Ref: SSD-82548708

**SECOND RESPONSE TO SUBMISSIONS SSD-82548708, RESIDENTIAL FLAT
BUILDING WITH INFILL AFFORDABLE HOUSING - 24, 26 & 28 MIDDLE HARBOUR
ROAD, LINDFIELD**

Attachment 1 - Ku-ring-gai Council's Second Response to Applicant's RTS	
1. Urban Design and Planning Issues	
Gross Floor Area	Matter for DPHI to be satisfied off.

Drawing Name
Deep Soil Diagrams

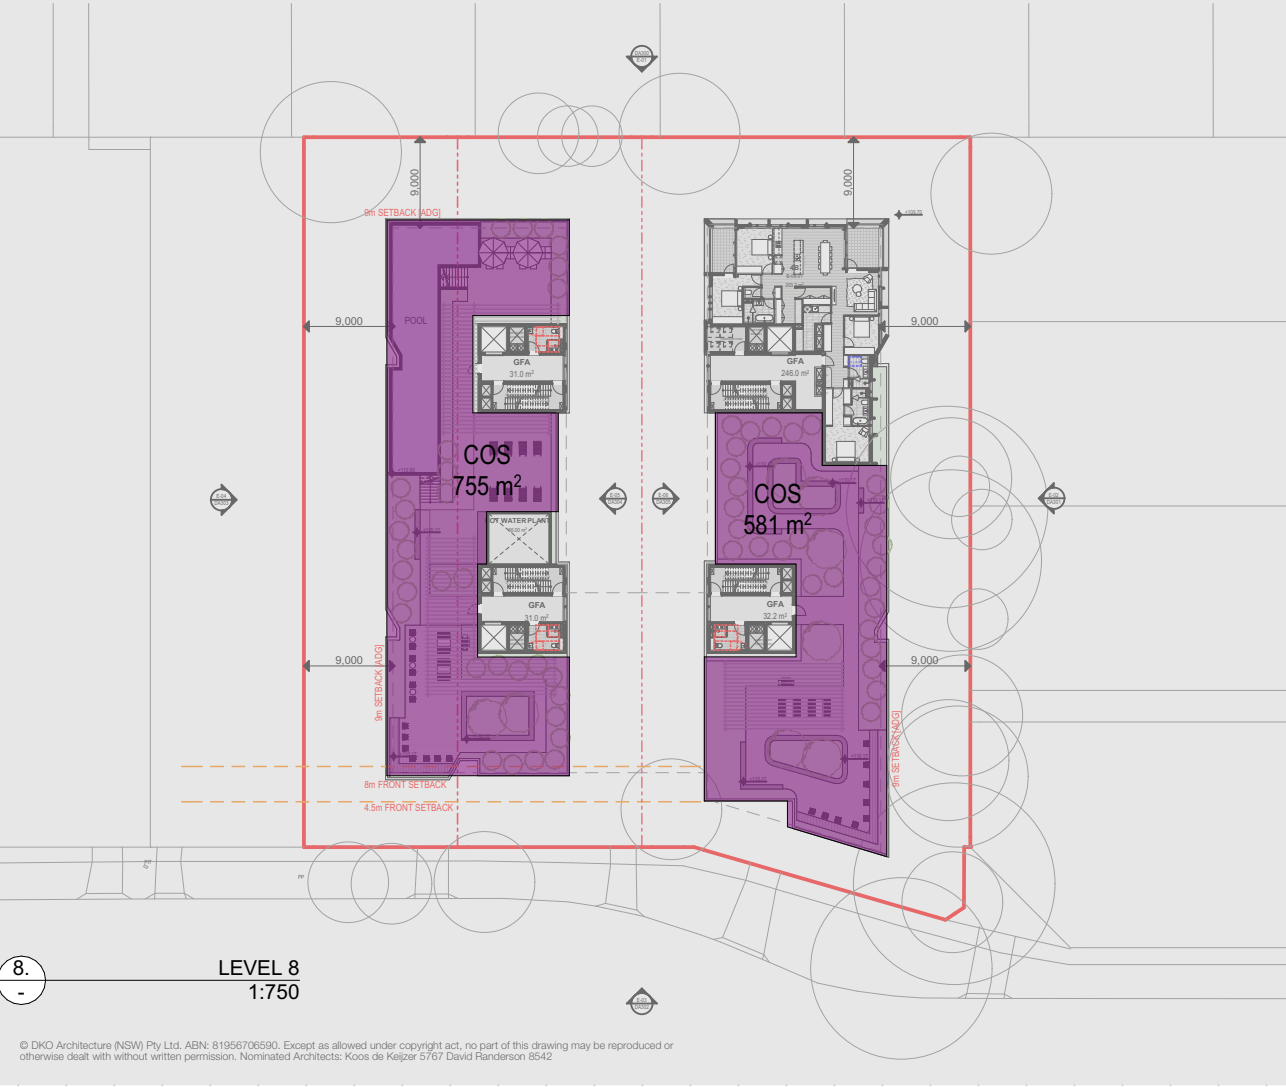
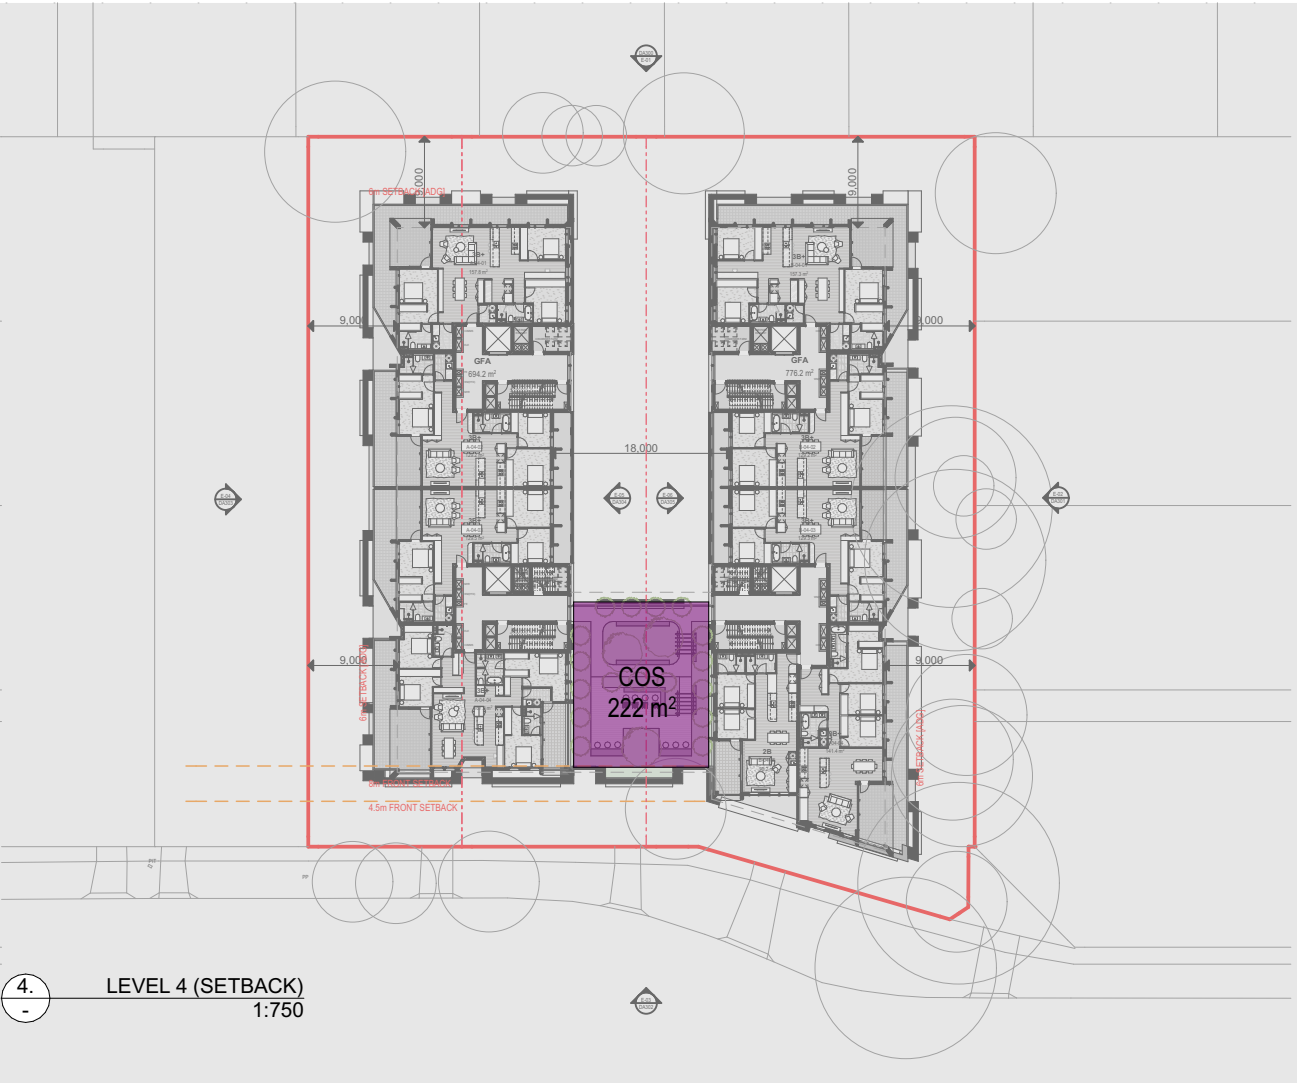
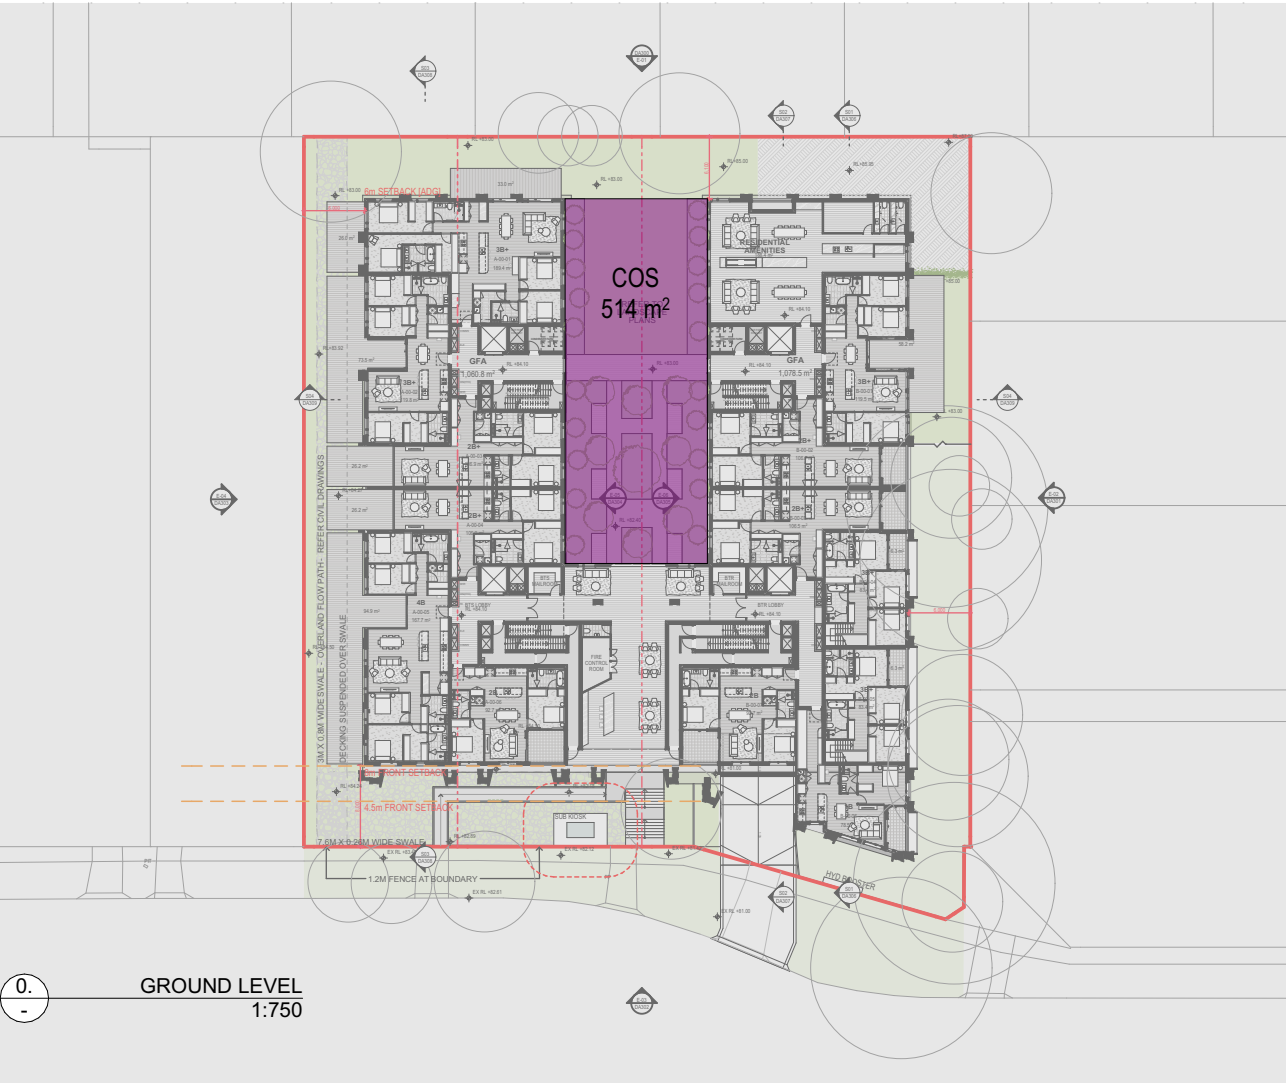
Insufficient Deep Soil zones	ADG inconsistency - Part 3E Deep soil zones Deep soil zone is defined as ‘<i>areas of soil not covered by buildings or structures within a development.</i>’ For sites greater than 1500sqm a minimum dimension of 6.0m is required by the ADG Objective 3E-1 Design criteria 1. It is assessed that as the site area of 4757m² is significantly larger than 1500m² the ADG design guidance of 15% deep soil should apply as a minimum. 15% site area equates to 713.5m². It is assessed that the development will result in a deep soil zone of only 407m² or 8% of the site area and is inconsistent with the ADG requirements failing to meet the 15% deep soil zone design criteria objective. The applicants deep soil compliance plan and calculable areas incorrectly includes areas that are inconsistent with the definition including: <i>The perimeter areas that do not meet the minimum 6.0m dimension.</i> <i>Impervious surfaces</i> <i>Services eg 525mm drainage line within the western setback and street frontage.</i> The lack of deep soil zones within site setbacks is inconsistent with ‘Greener Places’ design opportunities for viable supplementary tall tree plantings consistent with the established landscape character and streetscape and does not meet the ADG Objective 3E-1. UNRESOLVED - The architectural building footprint has not been adequately amended to address these issues. No revised Landscape Plans have been provided.
